**FFERM WYNT ALLTRAETH MONA / PROPOSED MONA OFFSHORE WINDFARM**

**CYFEIRNOD YR AROLYGIAETH GYNLLUNIO / PLANNING INSPECTORATE  
REFERECE: EN010137**

**RE: NATURAL RESOURCES WALES' RESPONSE TO THE EXAMINING  
AUTHORITY'S FIRST WRITTEN QUESTIONS**

Baseline Photography
Vol 6 Annex 8.6 Figure 42.1

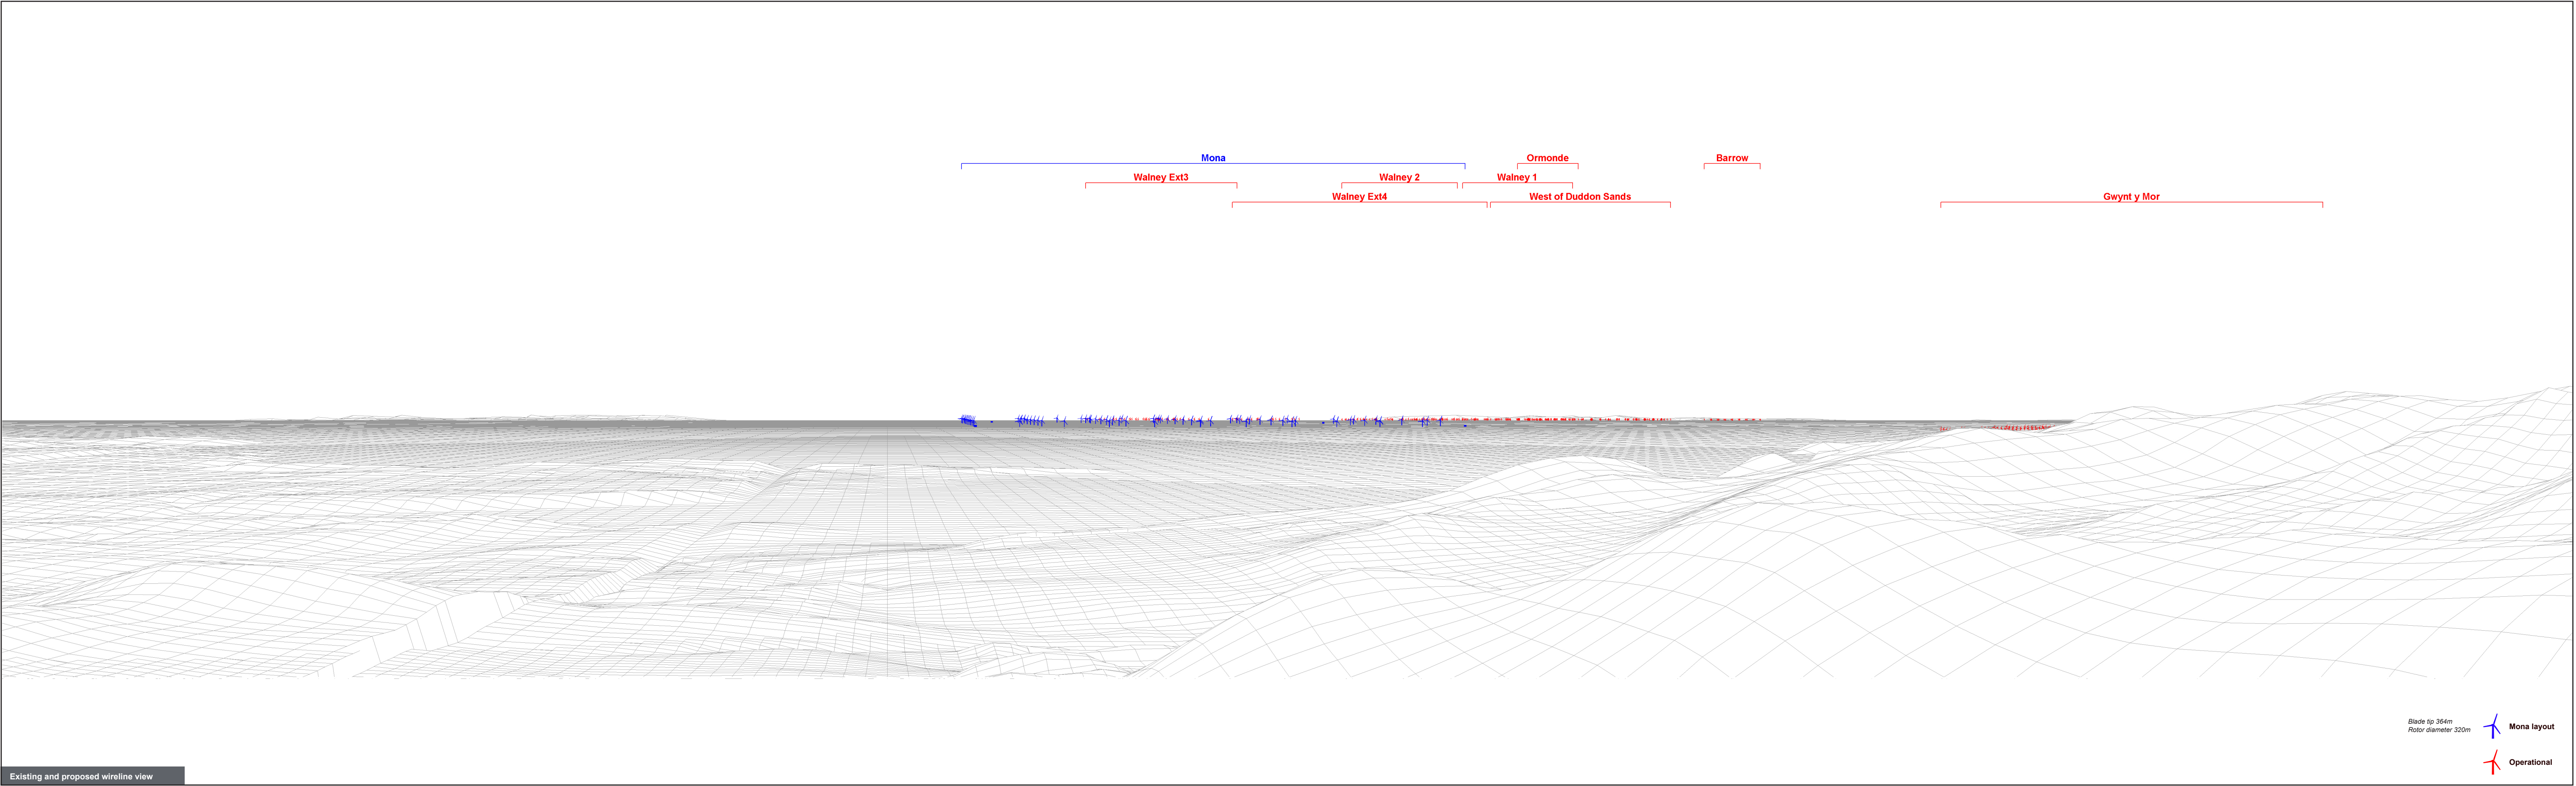
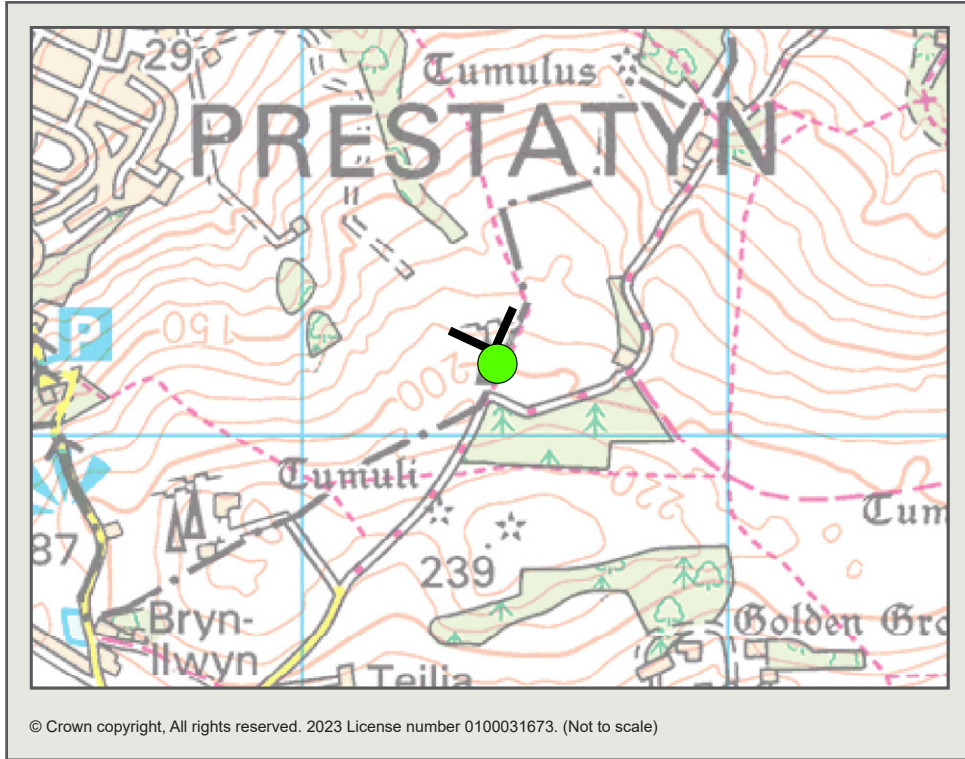
Question to:	Question:	NRW RESPONSE
		<ul style="list-style-type: none"> <li>• VP 26: Yr Arwydd trig point, near Mynydd Bodafon (Figures 22.1 - 22.2) [APP-108].</li> <li>• VP 55: Trwyn Eilian (Point Lynas) (Figures 44.1 - 44.2) [APP-111].</li> </ul> <p>Although a greater contrast between the sea and sky was achieved in the photographs at the other IoA NL viewpoints (below), low cloud and/or mist was present which means these visualisations also do not represent optimum visibility and clarity:</p> <ul style="list-style-type: none"> <li>• VP 2: Llanlleiana Head (Figures 2.1 - 2.2) [APP-106].</li> <li>• VP 3: Mynydd Eilian (Figures 3.1 - 3.2) [APP-106].</li> <li>• VP 24: Bull Bay, Amlwch (Figures 20.1 - 20.2) [APP-108].</li> <li>• VP 25: Moelfre Headland (Figures 21.1 - 21.2) [APP-108].</li> <li>• VP 28: Penmon Point (Figures 24.1 - 24.2) [APP-108].</li> <li>• VP 57: Trwyn Cemlyn (Figures 46.1 - 46.2) [APP-111].</li> </ul> <p>It is also advised that when using the visualisations on site, the landscape appears smaller in the photomontages than in reality. This means that when viewing the photomontages on site or at 100% on screen, the turbines will also appear smaller than they would in reality. This issue can be seen when comparing the Applicant's photomontages with those prepared from the same viewpoints for the Awel y Môr application. For example, compare VP 3 Mynydd Eilian in both applications<sup>4</sup>. The turbines from both schemes are located at a similar distance from this viewpoint, but the turbines within the Awel y Môr Array appear significantly larger, despite being smaller turbines.</p>
